CBL: 066 D0440 **Permit ID:** 2013-00435

Additional Comments:

SIGN LOCATION PLAN
NOT TO SCALE

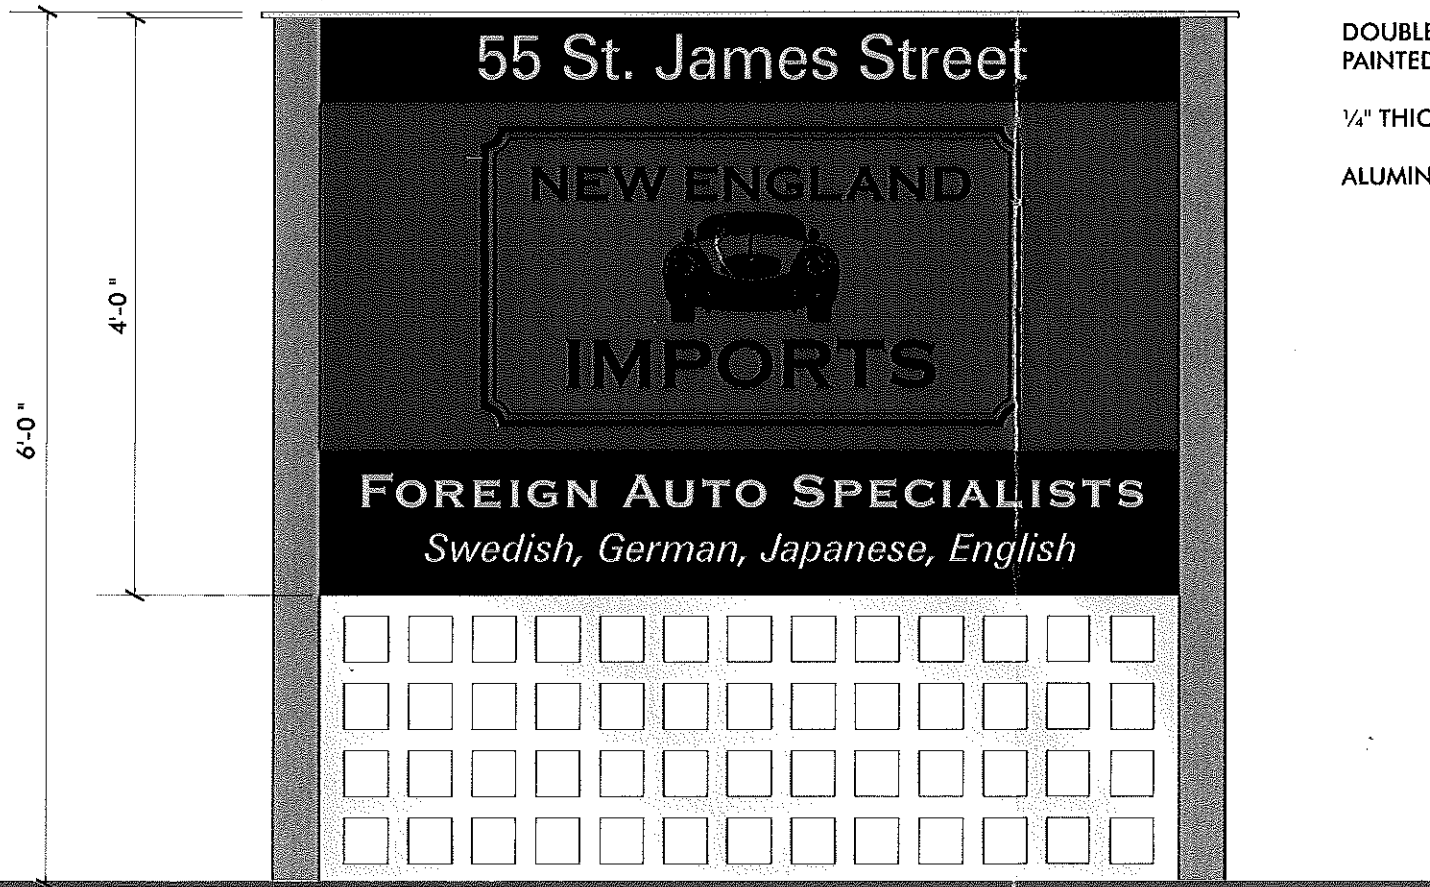
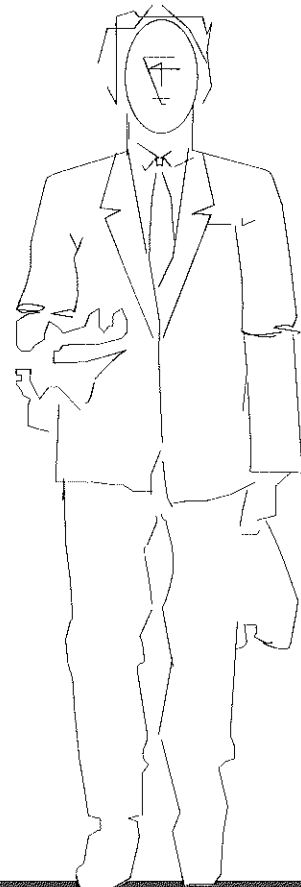
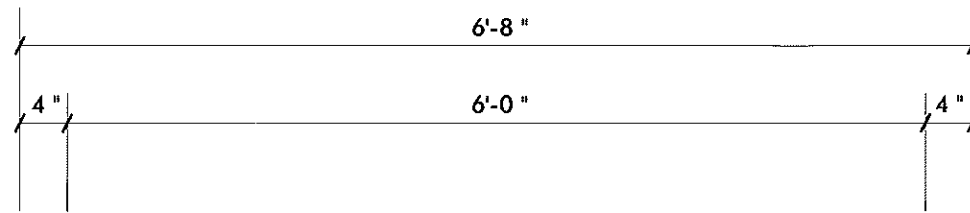
Looking at the GIS map and the old tax map, it appears that Larry Reminga does not own the strip of land in front of his building where he has a parking lot and wants to place the proposed sign. It look like ST.James Street got relocated at some point. I have an email into Bill Clark.

Received email from Bill Scott. MDOT owns the strip of land in front of 55 St. James St. I just called Patrick Bolduc at Neokraft. I told him that the MDOT owns the land and the applicant can't put a sign on property that they don't own. The permnit is on hold until Patric gets back to me about what the applicant wants to do.

Revision info received; per e-mail (in G drive and E plan). Took off hold and put in payment pending. Still owes \$22 in addition to what was already paid.
